Development Review Board Comments

Project Number: 1003393
Application Number: 04DRB-00601

Lots 12 through 16, Block 8, Enchanted Mesa

DEVELOPMENT REVIEW BOARD--SPEED MEMO

SITE PLAN

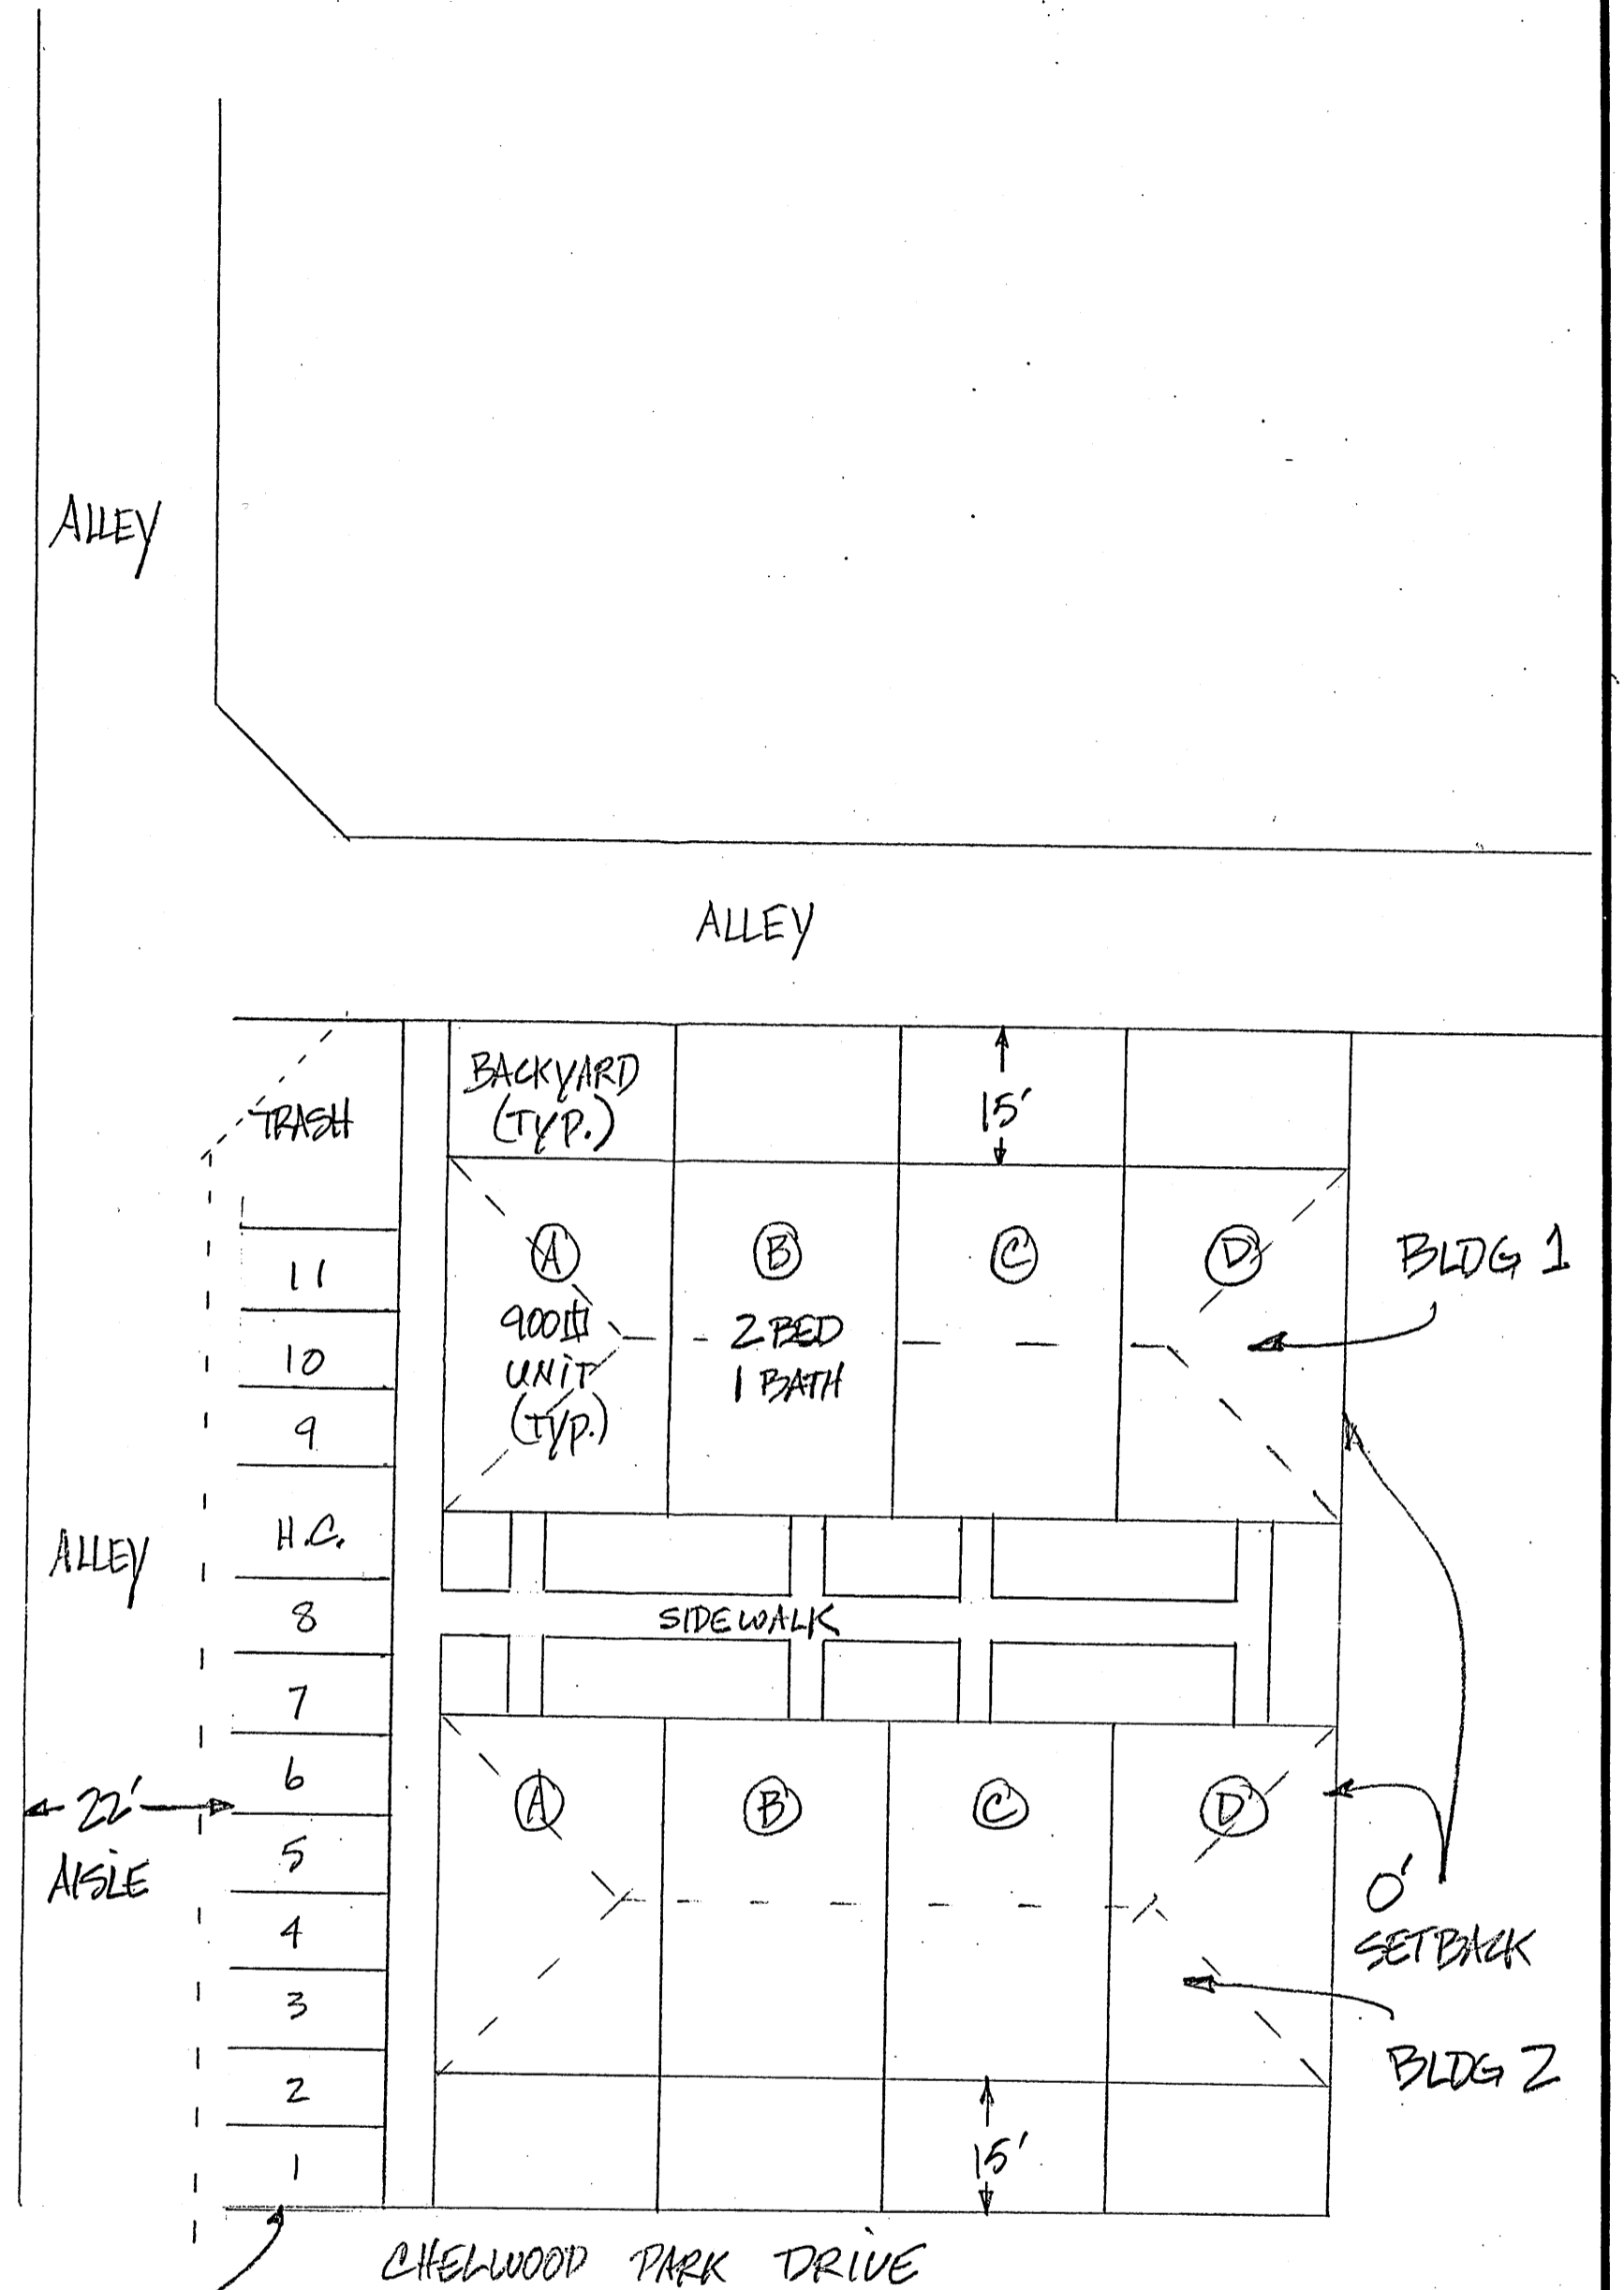
- 1) Alleys will need to be paved. Are both 20' wide?
- 2) Need x-section of Chelwood. Are bikelanes in place?
- 3) Property lines should be 9' from face of curb.
- 4) Parking spaces need to comply with DPM.
- 5) Placement of trash enclosure needs Solid Waste Management approval.

Residential uses in a C-1 zone are conditional uses only. If applicant plans to build additional apartments, approval by the Zoning Hearing Examiner is required.

Which alley is proposed for vacation? The adjacent property owners must consent to the vacation if it is a public alley.
